**From:** Andrew Robley  
**Sent:** 28 April 2017 12:47  
**To:** Sam Dicocco <[s.dicocco@welhat.gov.uk](mailto:s.dicocco@welhat.gov.uk)>  
**Subject:** FW: H191 RE: 6842\_170314\_Oshwal Centre\_rear extension\_final solution\_01\_fr  
paolo\_6842\_C7

PROPOSED RIGHT SIDE ELEVATION

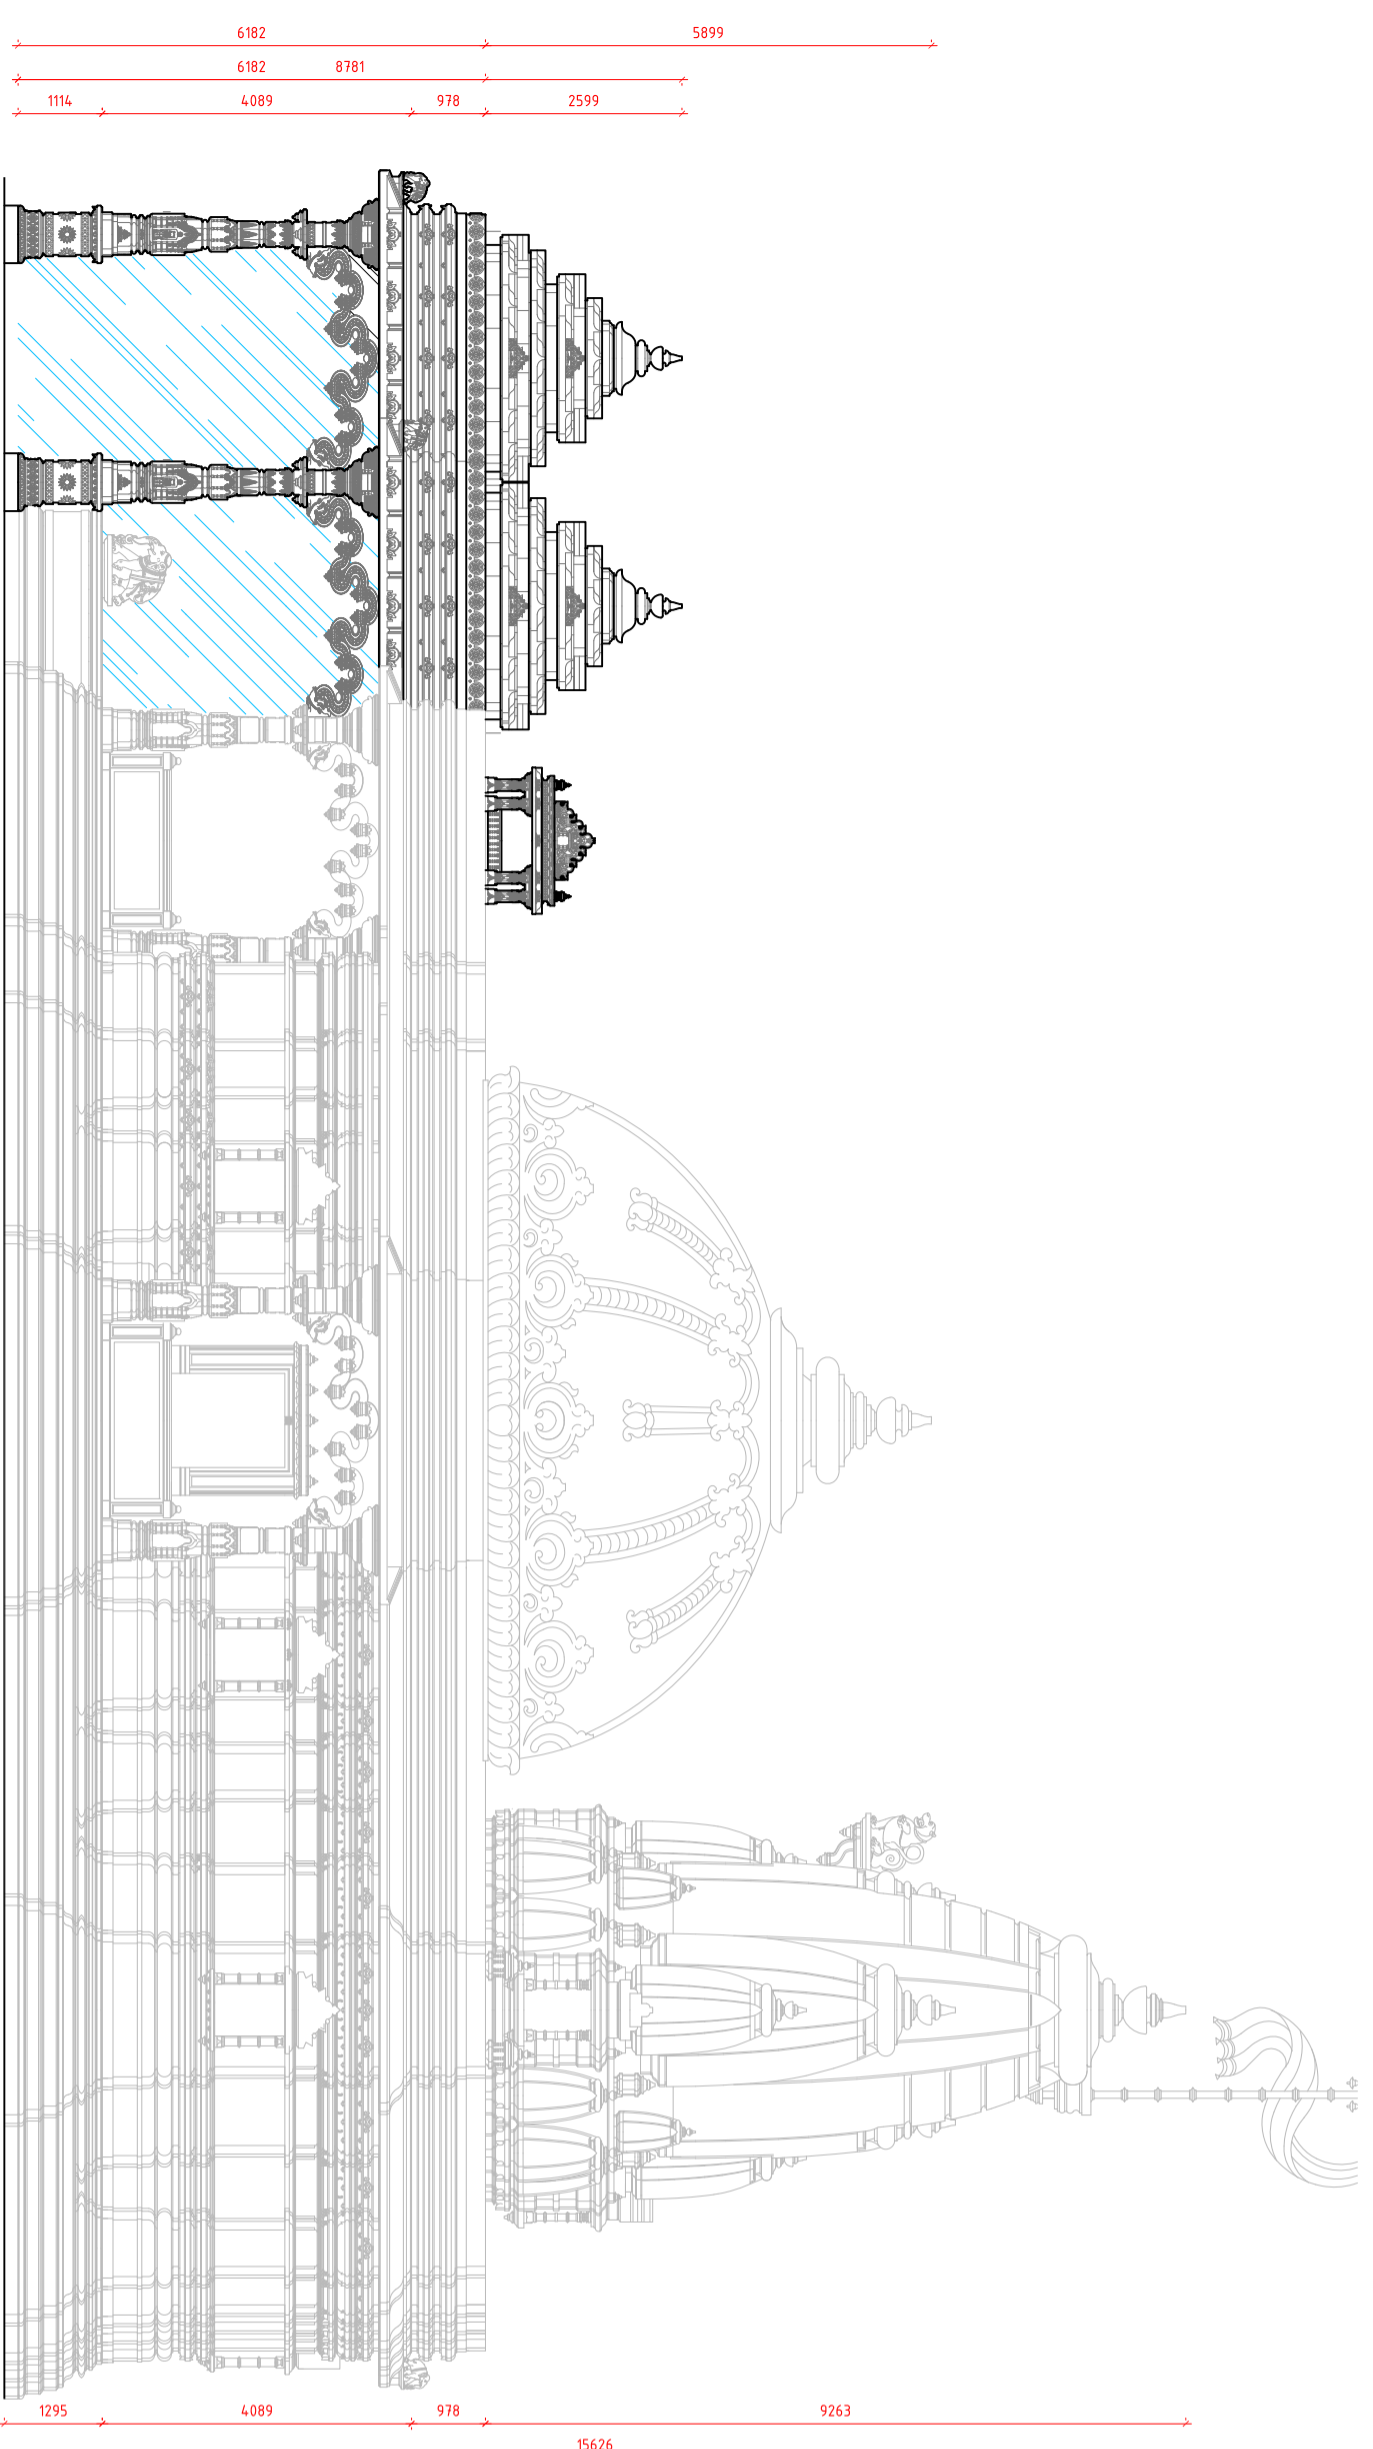
As I hinted, the glazing bars for the French doors may have to be modified because it is unlikely that the number of panes shown would fit in without becoming too fussy. However we could control this by specific conditions.

Notwithstanding the approved drawings, the glazing pattern of the French doors should be re-considered as part of the above condition
